From: [REDACTED]
Sent: 04 December 2014 12:30
To: Planning.Responses
Subject: Planning consultation on: A/154/14/OUT
Attachments: Pond Place Roundstone Lane Angmering.pdf

Your Ref: A/154/14/OUT

Re: Pond Place, Roundstone Lane, Angmering, BN16 4AL.

Thank you for your correspondence of 10th November 2014, advising me of an outline planning application for a proposed development of 18 dwellings at the above location, for which you seek advice from a crime prevention viewpoint.

SITE PLAN

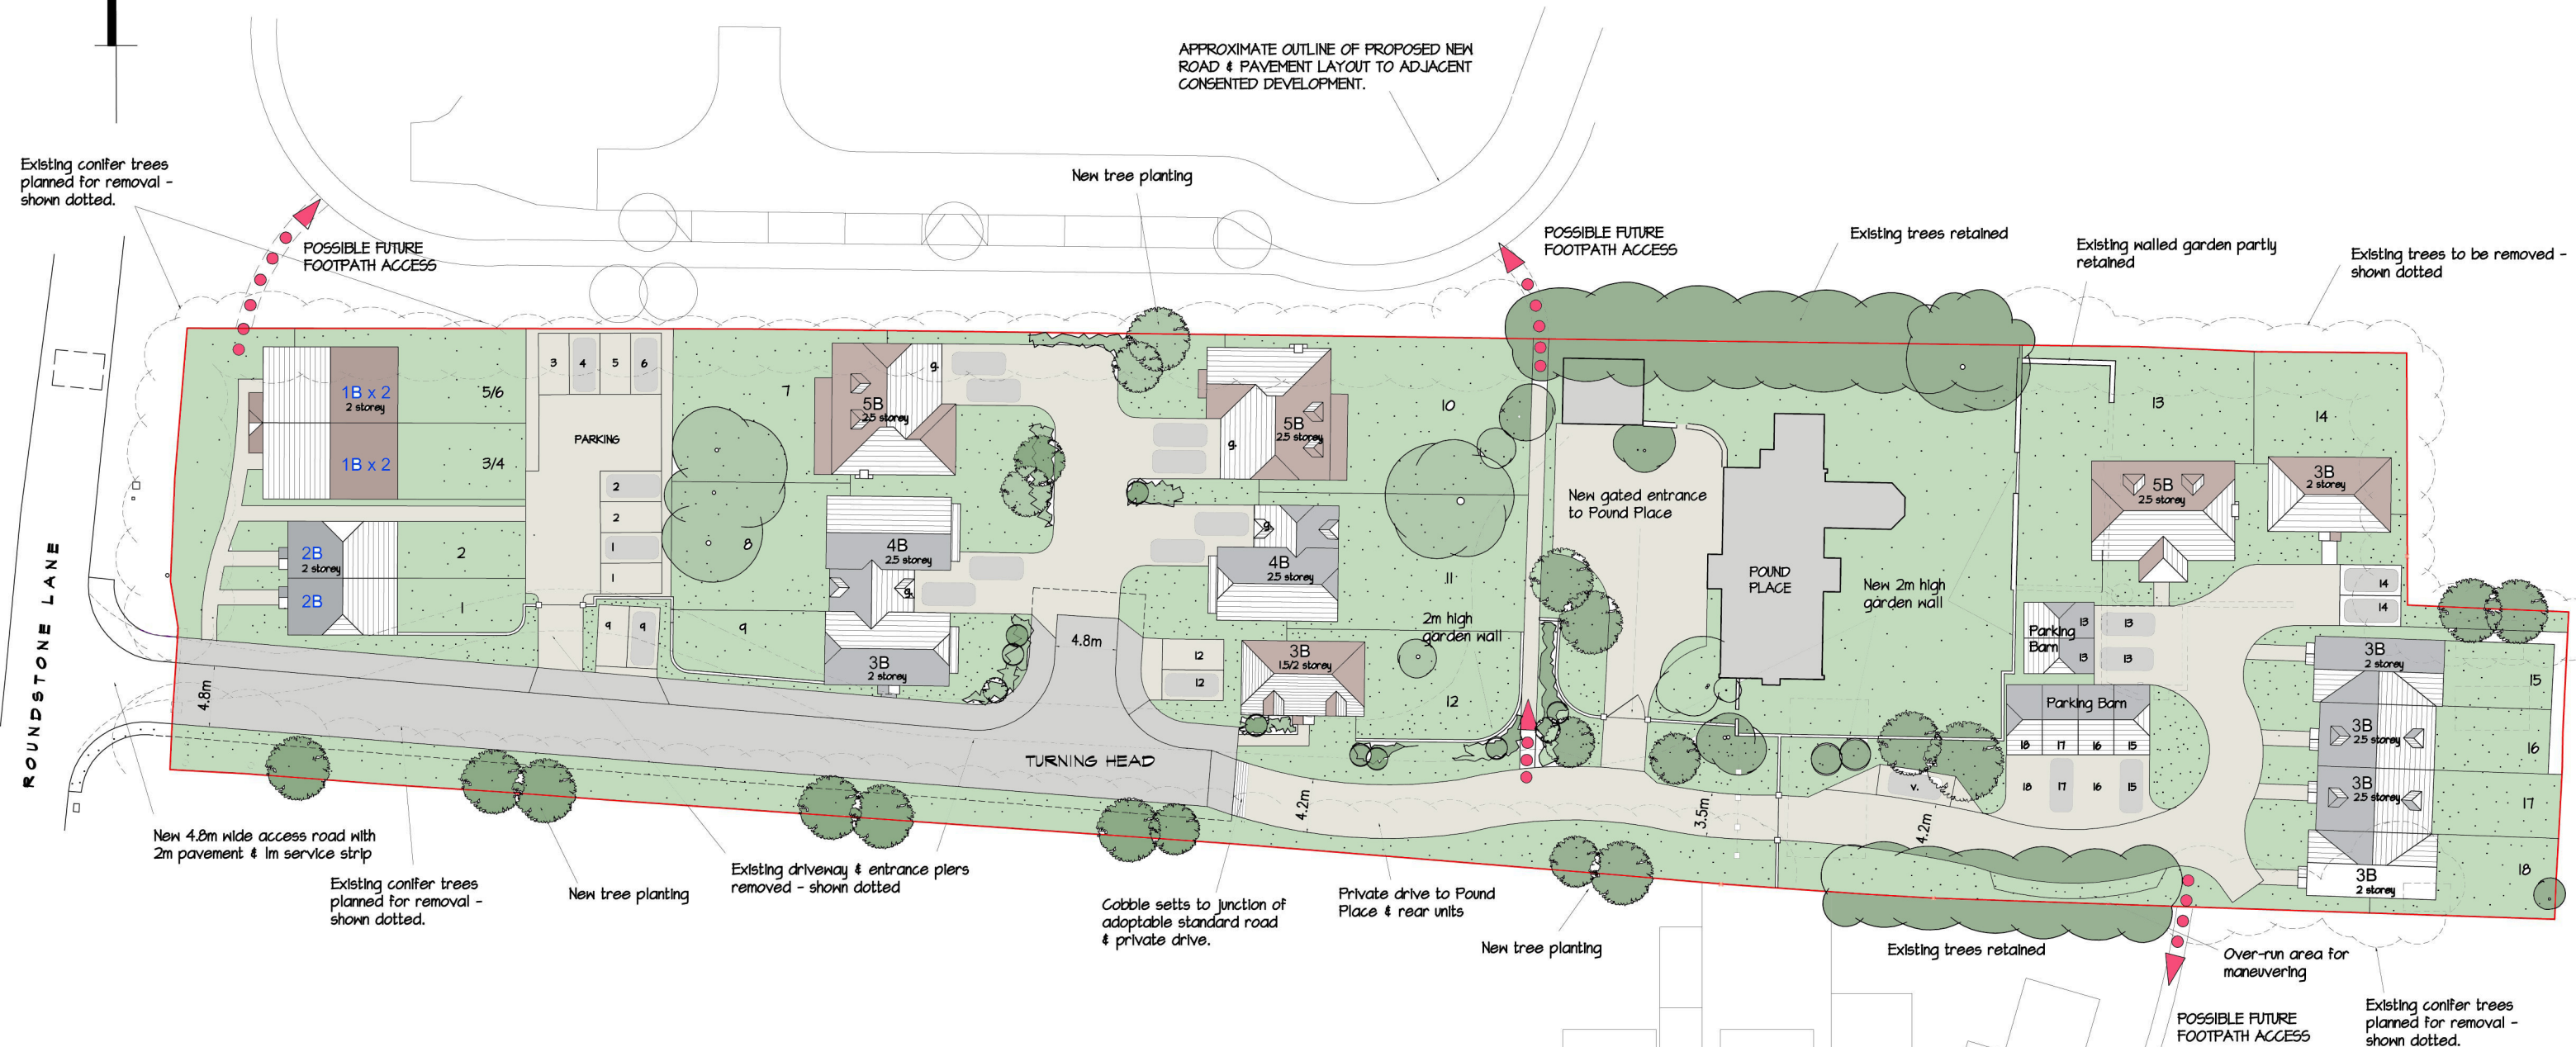
The development in the main has outward facing dwellings which has created good active frontage with the streets and the public areas being overlooked. There are proposed foot paths behind plots 10 – 12 which provides access to the rear of the 3 properties and Pound Place, and between plots 2 & 3/4. I do not recommend these pathways. Should a linking footpath access be require consideration is be given to a peripheral footpath that does not cause excessive permeability into or through the development.

Parking has been provided for with a combination of; in-curtilage, an overlooked rear parking court, car barns and street parking. Where communal parking occurs it is important that they must be within view of an active room within the property. An active room is where there is direct and visual connection between the room and the street or the car parking area. Such visual connections can be expected from rooms such as kitchens and living rooms, but not from bedrooms and bathrooms. Gable ended windows can assist in providing observation over an otherwise unobserved area. There is poor surveillance over the car barns from the adjacent properties; this should be from an active room within the dwelling. In the interest of security and safety the car barns should have PIR illuminated lighting fitted internally.

It is important that the boundary between public space and private areas are clearly indicated. It is desirable for dwelling frontages to be open to view, so walls fences and hedges will need to be kept low or alternatively feature a combination (max height 1m) of wall, railings or timber picket fence. As the first line of defence, perimeter fencing must be adequate with vulnerable areas such as side and rear gardens needing more robust defensive barriers by using walls or fencing to a minimum height of 1.8metres. In circumstances that require a more open feature such as a garden overlooking a rear parking court, 1.5m close board fencing topped by 300mm of trellis can achieve requirements, security and surveillance. Gates that provide access to the side of the dwelling or rear access to the gardens must be robustly constructed of timber, be the same height as the fence and be lockable. Such gates must be located on or as near to the front of the building line as possible.

It is important to avoid the creation of windowless elevations and blank walls adjacent to space to which the public have access such as plot 2. These can have the effect of attracting graffiti and inappropriate loitering. An addition of a first floor window or a buffer zone can assist in reducing these concerns. Buffer zones can take the form of railings or defensible planting or a combination of both, i.e. the railing to indicate the private space and the planting to prevent direct access, this is also very affective on vulnerable windows.
